DEVELOPMENT REVIEW BOARD--SPEED MEMO

DRB CASE NO/PROJECT NO: 1007347

Project Name: JOURNAL CENTER

RE: Tract 4AA-6A, Journal Center

SKETCH PLAT
Proposed TRACTS 4AA-6A-1 & 4AA-6A-2

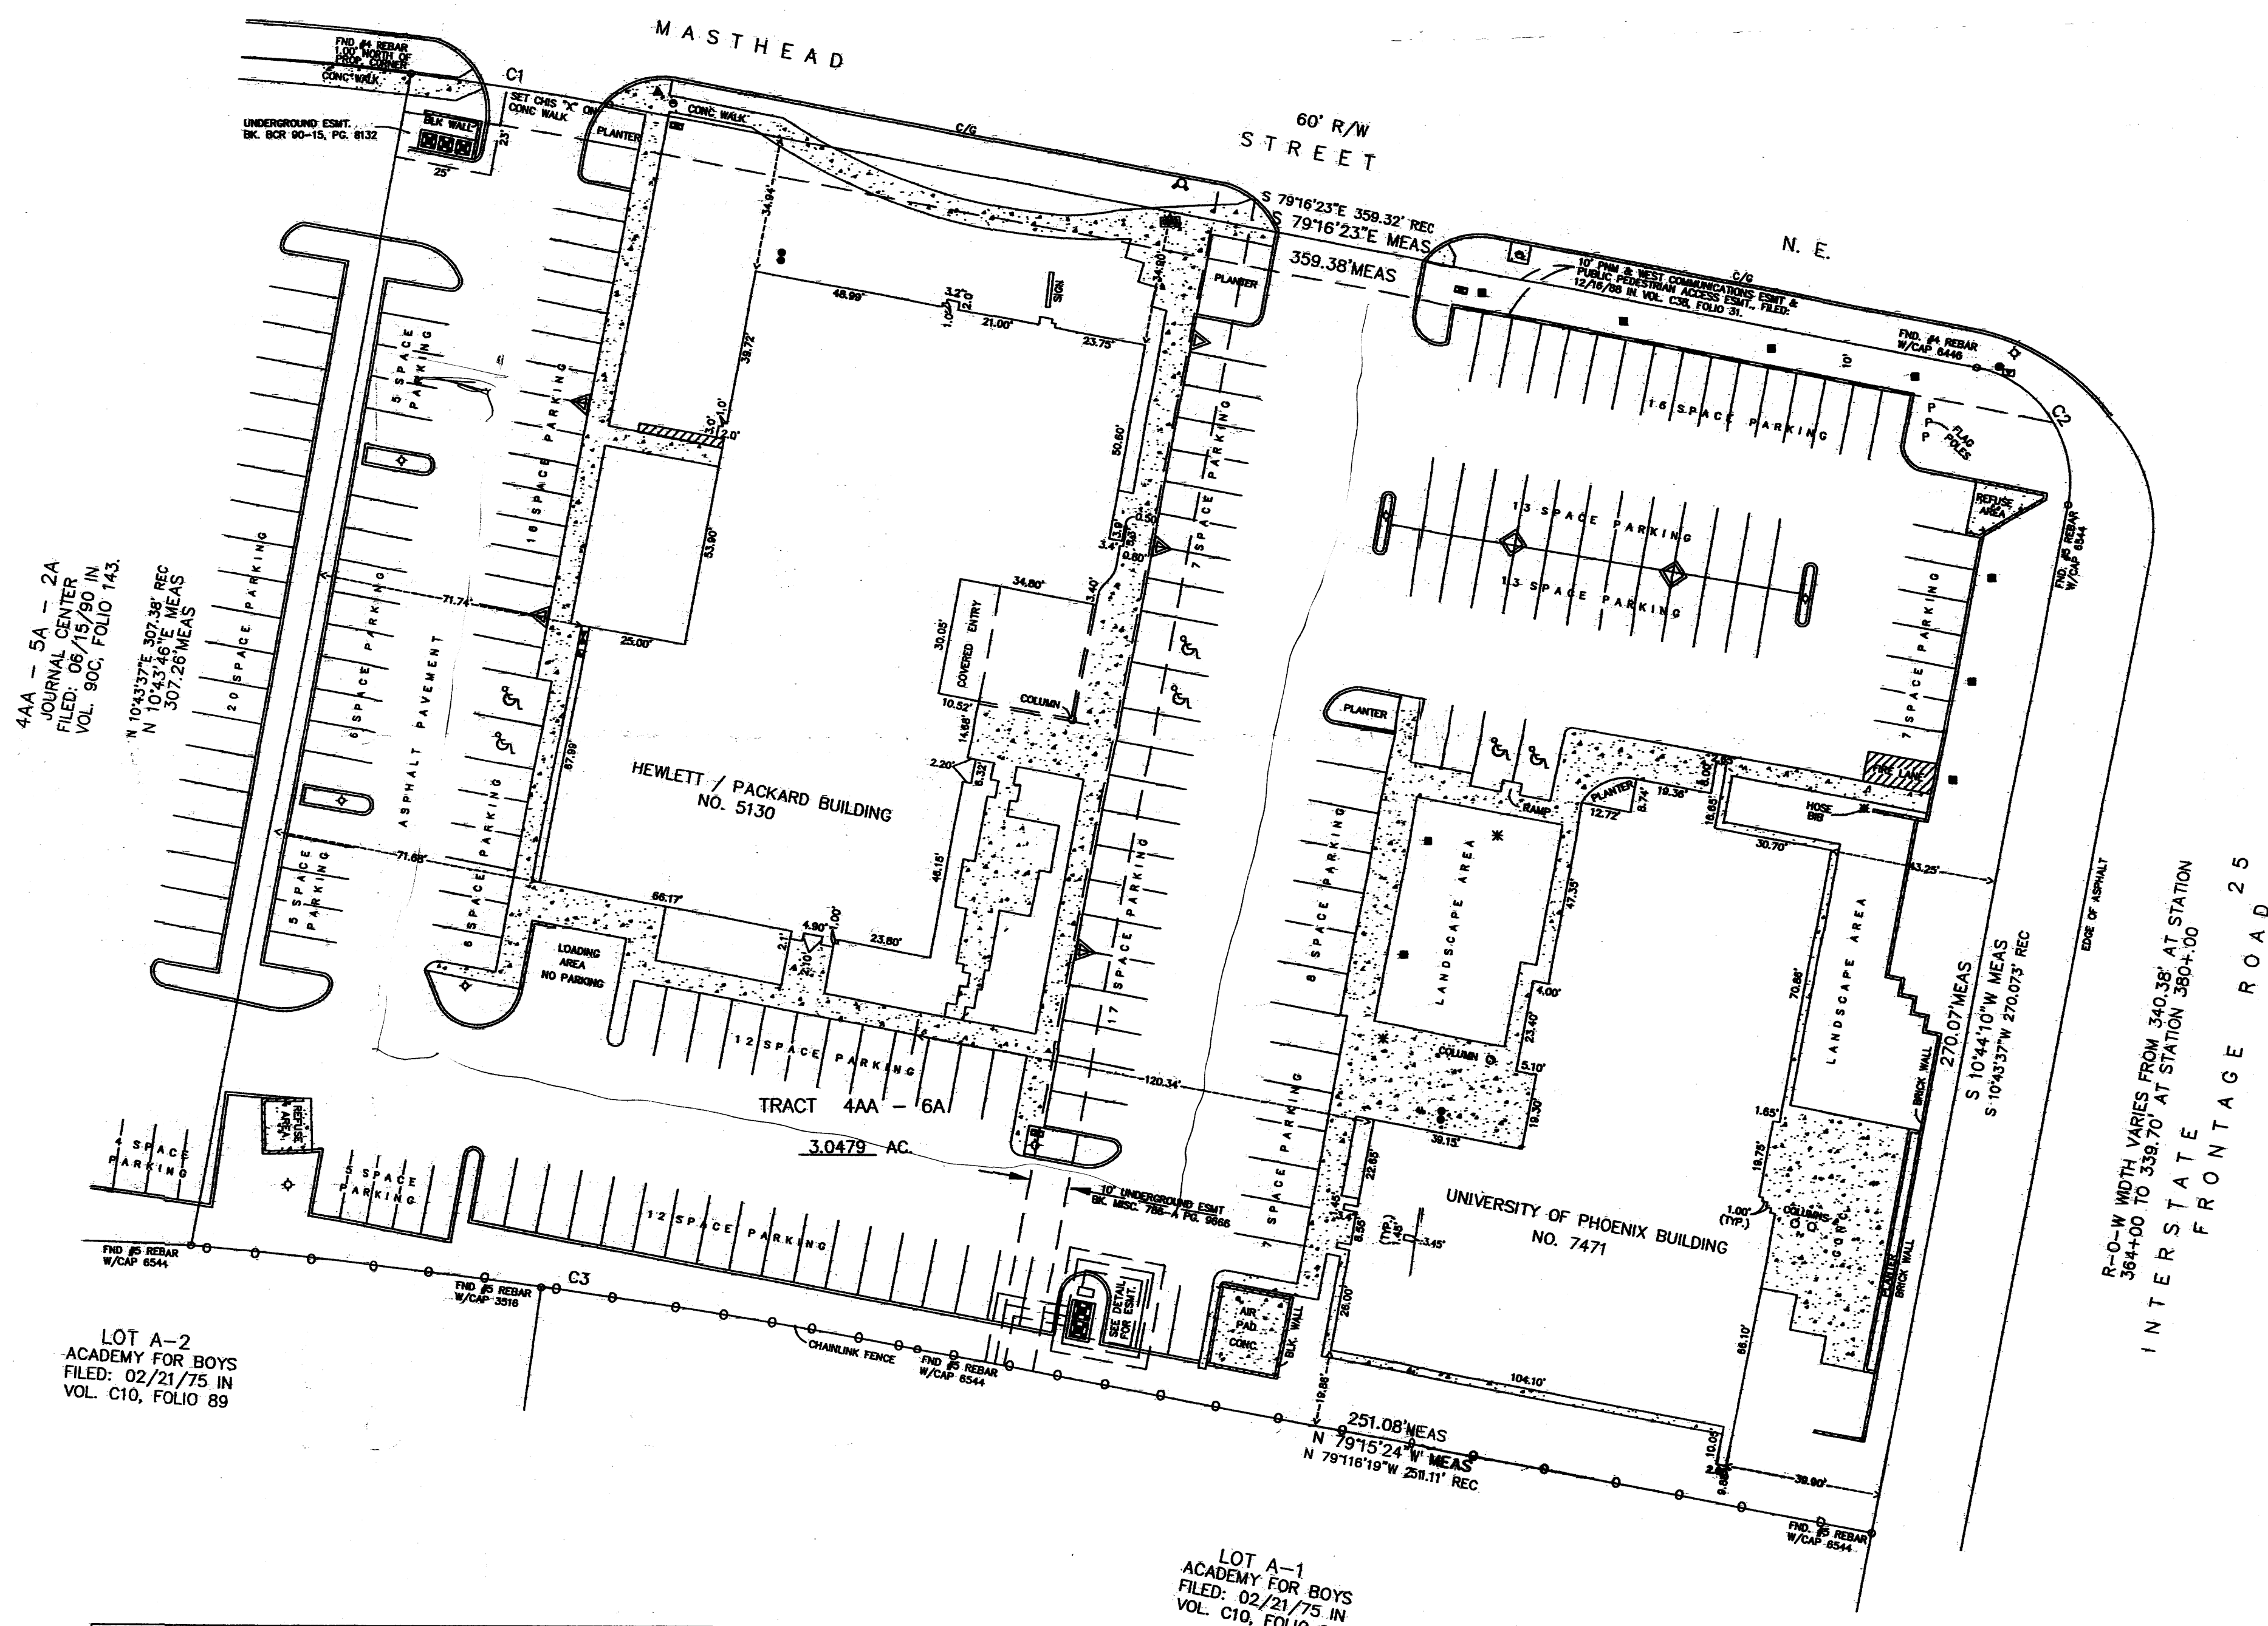
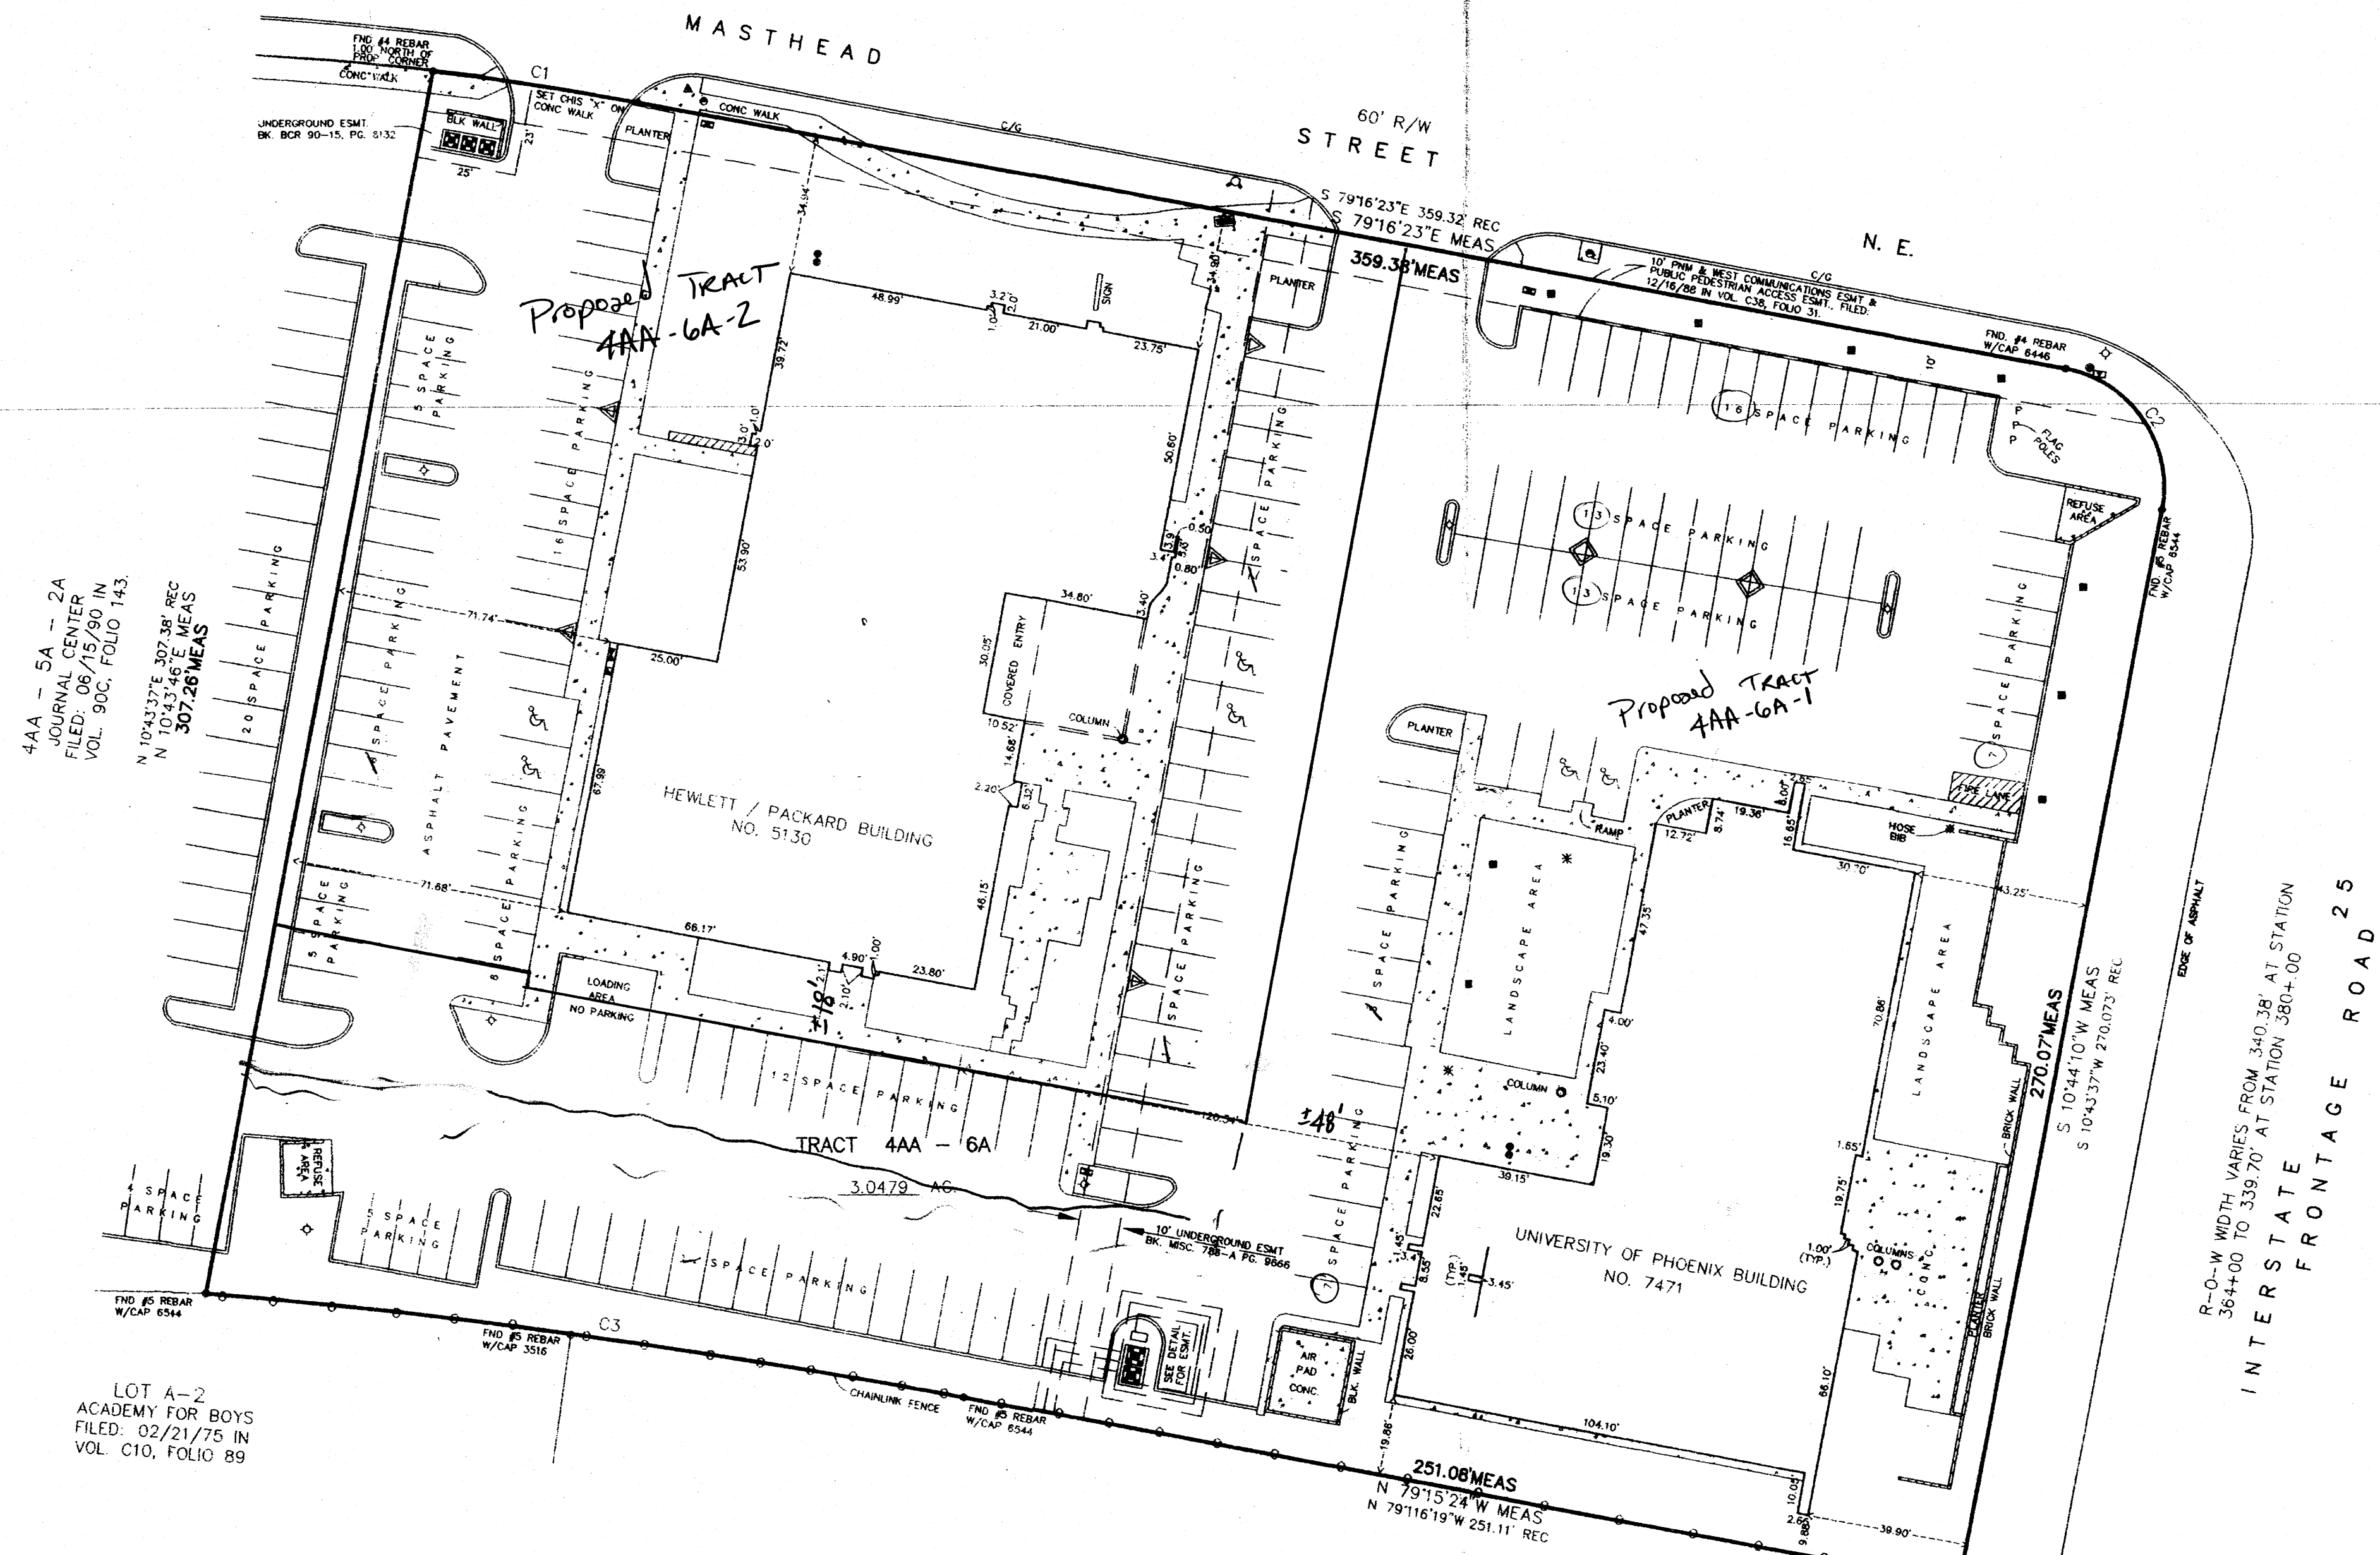
Reciprocal Access, Parking, and Drainage Easements will be required for proposed subdivision. Associated parking rows (including landscape islands) need to be included in proposed Tract 4AA-6A-2; new property line would best follow centerline of driveway.

Need cross-lot drainage easement.
